Your ref: 3/2018/0033 and 0034

Planning Applications 3/2018/0033 and 0034: Proposed single storey extension to the rear of the existing ground floor rear kitchen annex to form new customer disabled WC. Refurbishment of existing first and second floor accommodation in relation to finishes. Creation of two parking spaces to the rear garden. 18 Parson Lane, Clitheroe BB7 2JN

Proposed Ground Floor Plan

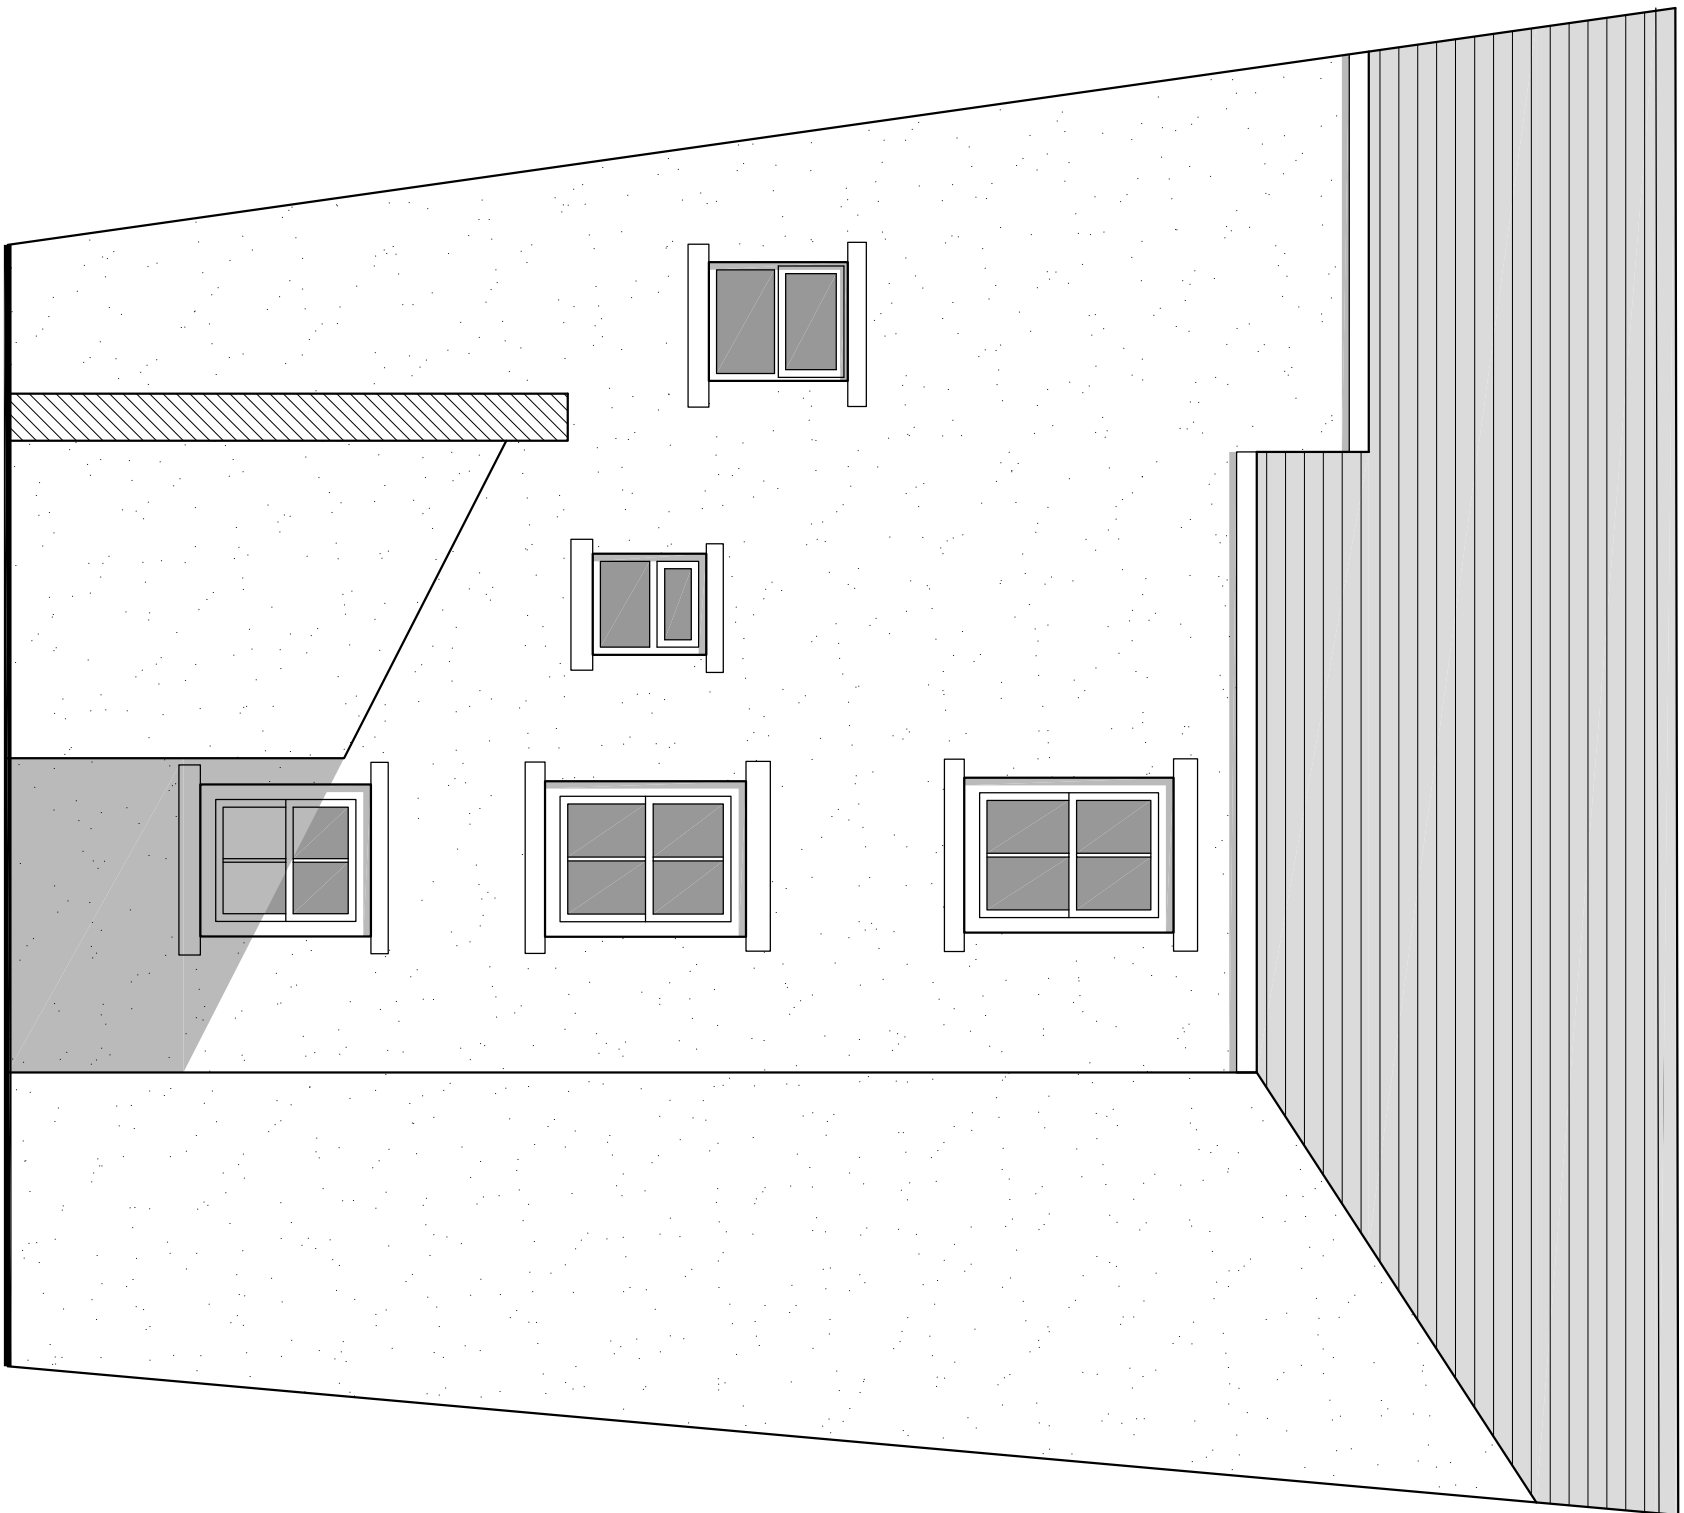
With regard to the impact on the buried archaeological resource, this is hard to judge with the information provided as part of the application. Some disturbance is clearly necessary for the construction of the extension, but this appears to be on a site which has already been disturbed by the construction and subsequent demolition of the north end of the later 19th century outshut. The area of the proposed parking spaces in the rear garden is shown on the development plans, but existing and proposed levels are not marked on the plan, nor has a proposed section drawing been provided. Plates 5 and 6 in the Heritage Statement would suggest that the present garden area is significantly raised above the floor level of the adjacent part of 20 Parson Lane but approximately level with that to 16 Parson Lane. They also suggest that the access to this area also falls unevenly towards the rear (north and west). Some engineering work appears to be necessary as part of the construction of the parking area and its access, but this could involve cutting down the garden, building up the access, or a combination of both. As noted above there is some potential for early remains to exist in this part of the plot and thus that they will be disturbed by the development works. The significance of this potential disturbance is hard to judge without knowing its scale, but it is unlikely that it would produce such a major negative effect as to justify the refusal of the application on these grounds alone.

If the council are minded to approve the proposals, we would recommend that prior to a decision being made a detail is supplied to us that clearly sets out the area and depth of any excavation required to construct the proposed parking area and its access. We would then be in a position to make an informed judgement as to the need for and scope of, any archaeological mitigation that may be appropriate.
